# CITY OF ALBUQUERQUE

**Re: McMahon Shopping Center**  
**10550 Unser Blvd NW**  
**Traffic Circulation Layout**  
Architect's Stamp 07-20-2021 (A11-  
D017B)

Based upon the information provided in your submittal received 11-16-2021, the above referenced plan cannot be approved for Building Permit until the following comments are addressed:

PLAT OF
UNSER AND MCMAHON CENTER
WITHIN THE TOWN OF ALAMEDA GRANT
PROJECTED SECTION 2, TOWNSHIP 11 NORTH, RANGE 2 EAST, N.M.P.M.
CITY OF ALBUQUERQUE
BERNALILLO COUNTY, NEW MEXICO
SEPTEMBER 2021

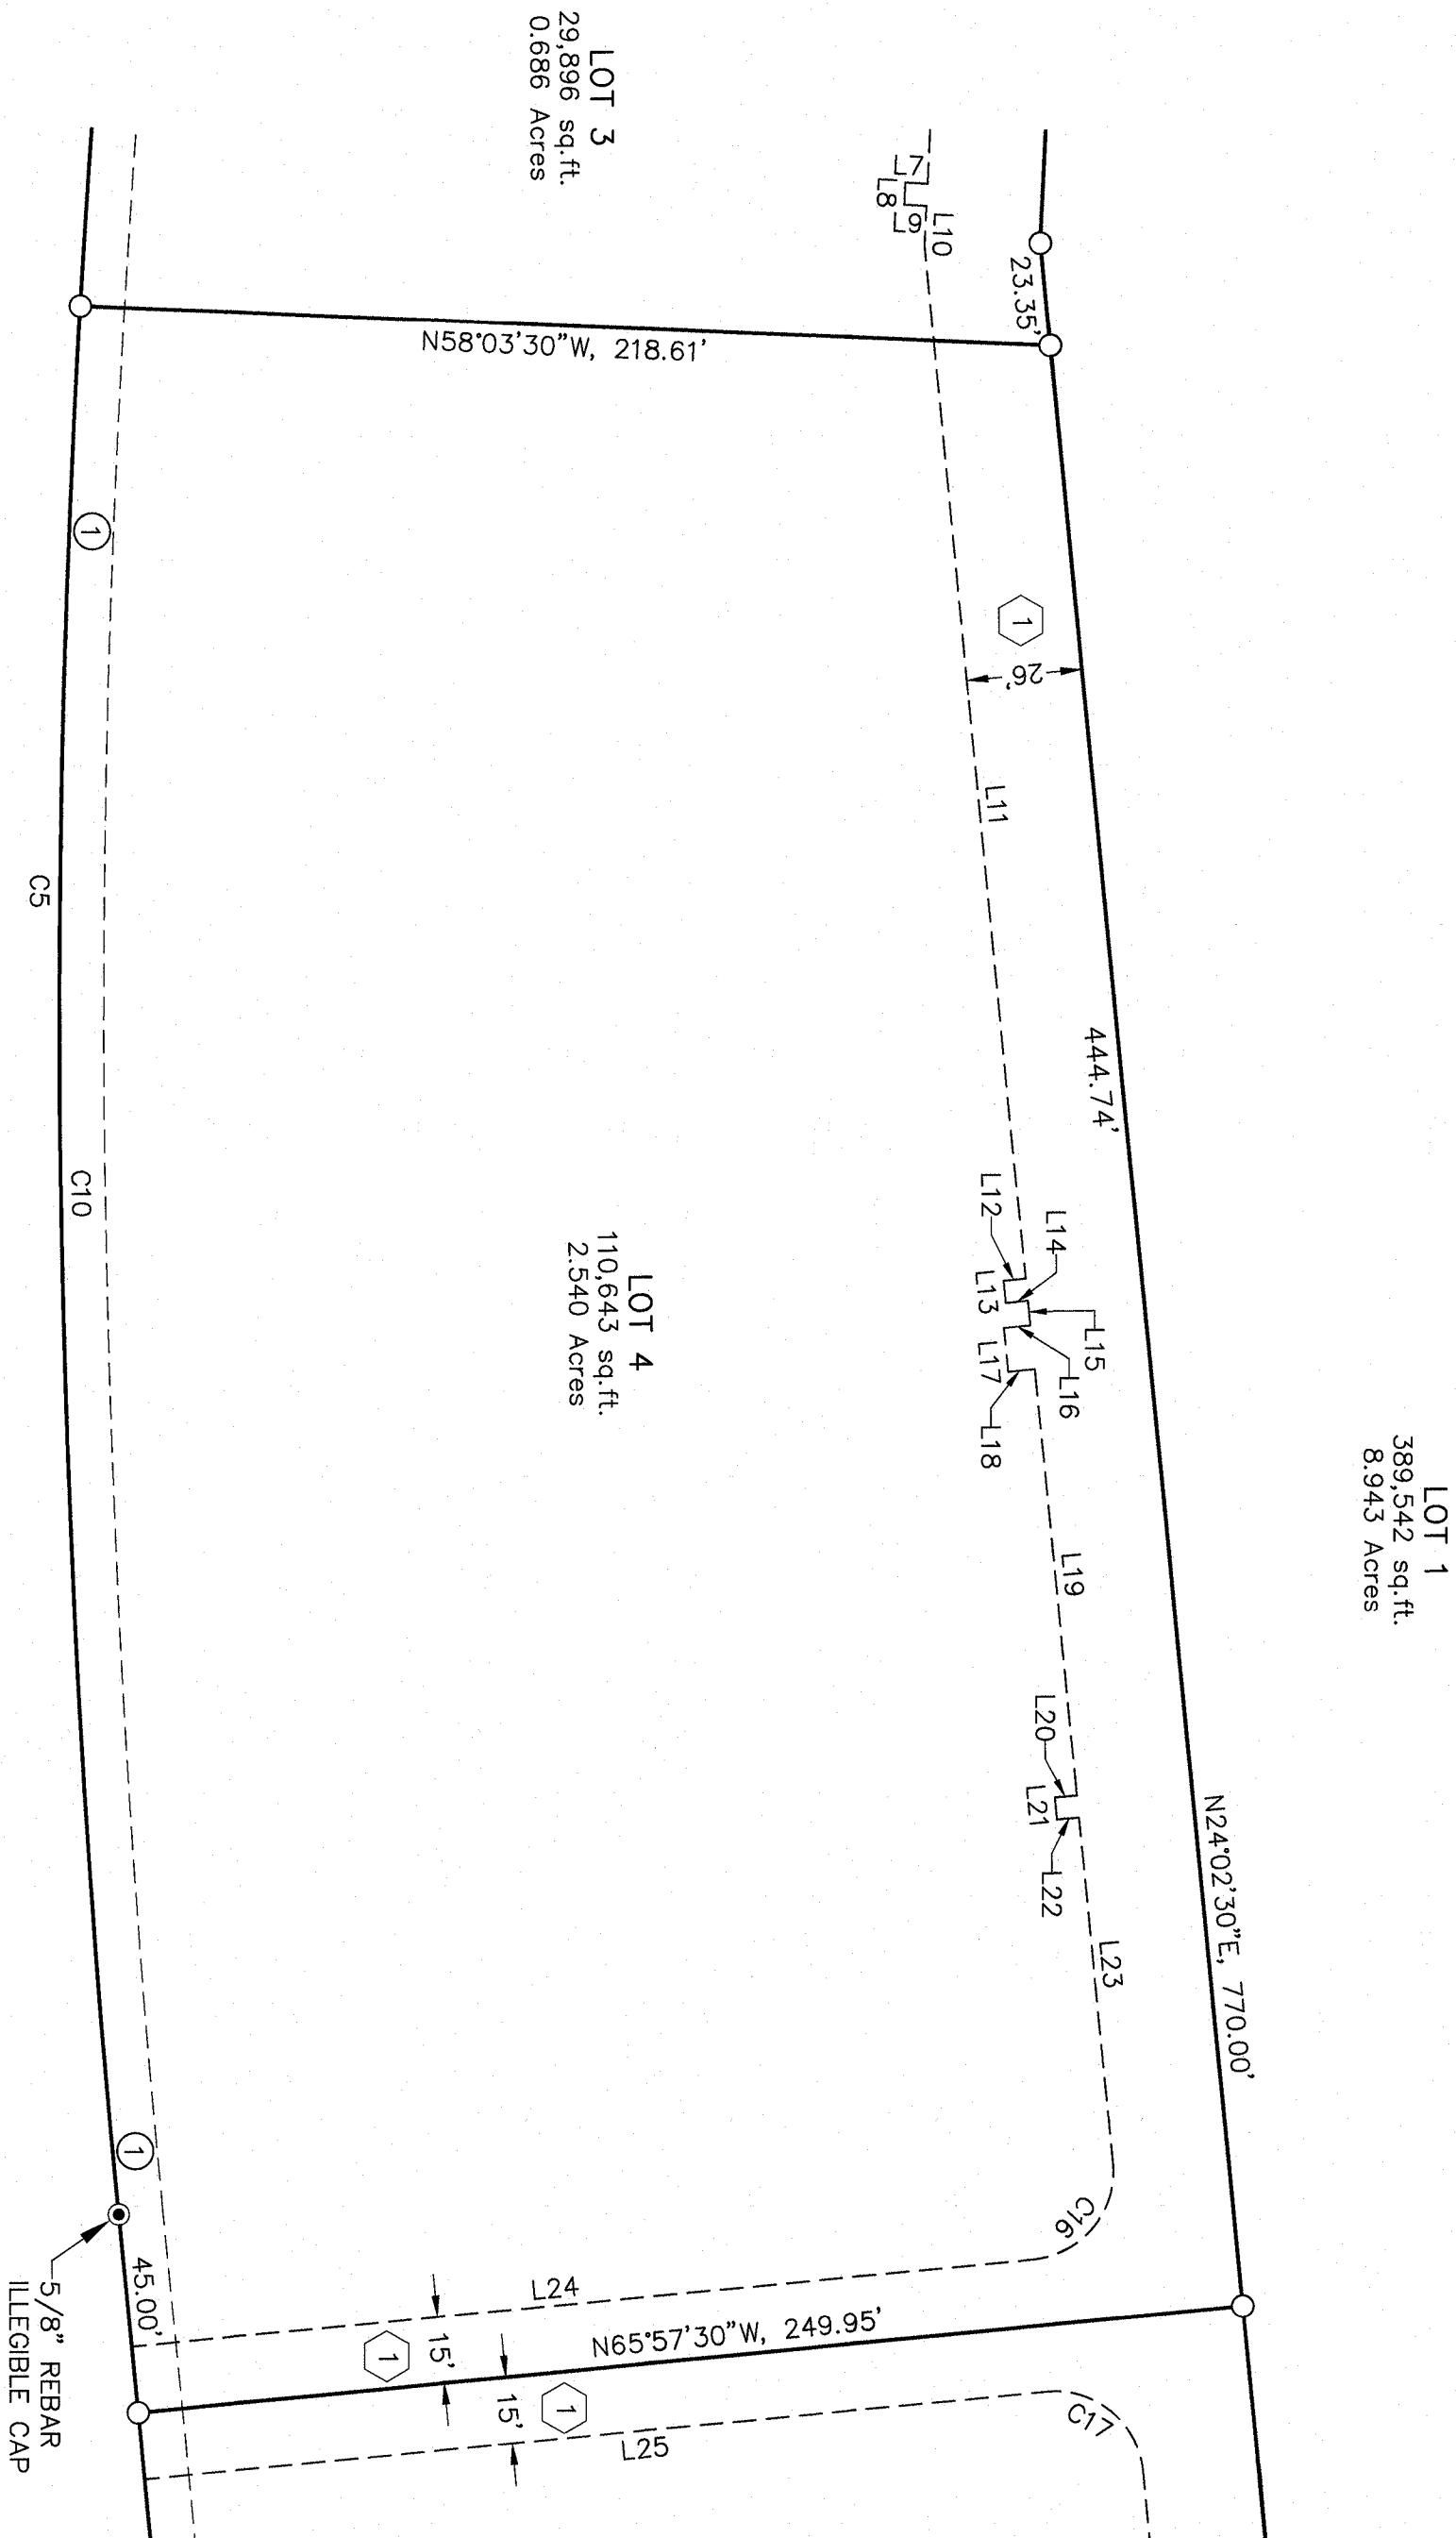
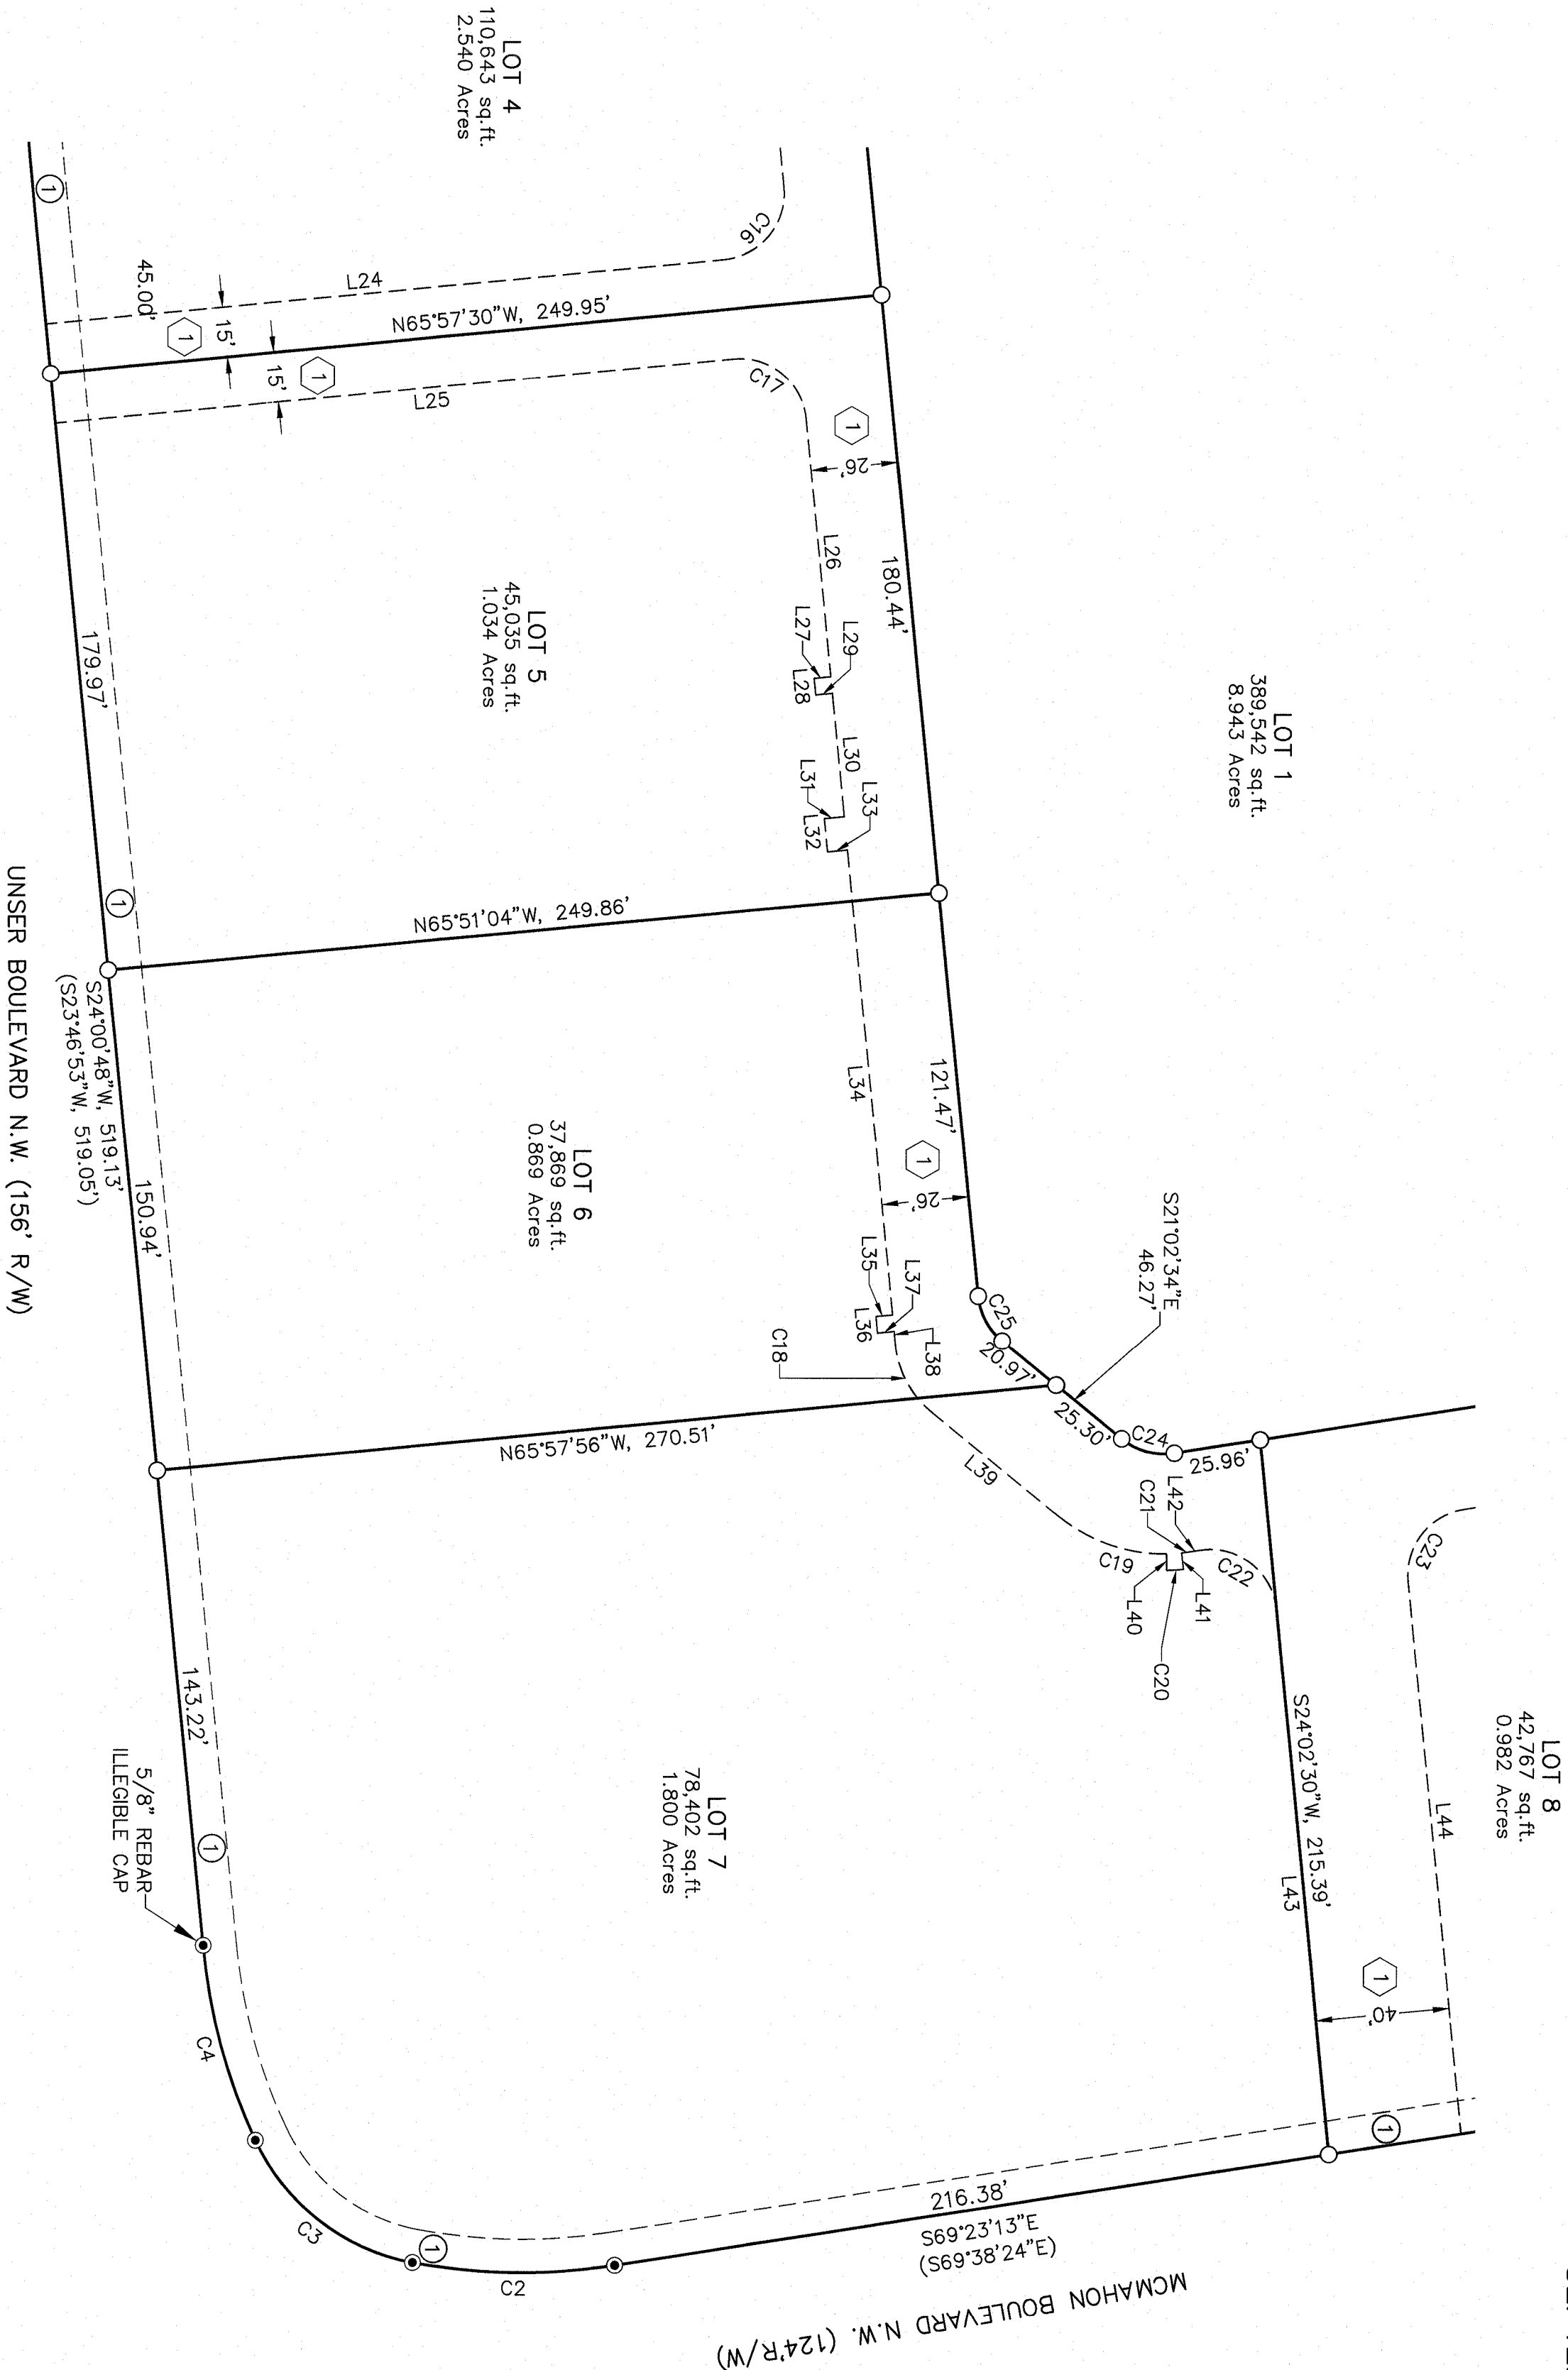
1. An approved PLAT will need to be provided to demonstrate plotted tracts/lots. **This includes all 7 sheets.** I will need these sheets to review all access/pedestrian easements being proposed on this TCL project.

- You will need adjacent land owner permission to have ramp or property. Of course, the Plat hopefully shows an easement for this encroachment and/or land owner agreement to have ramp located on their frontage.
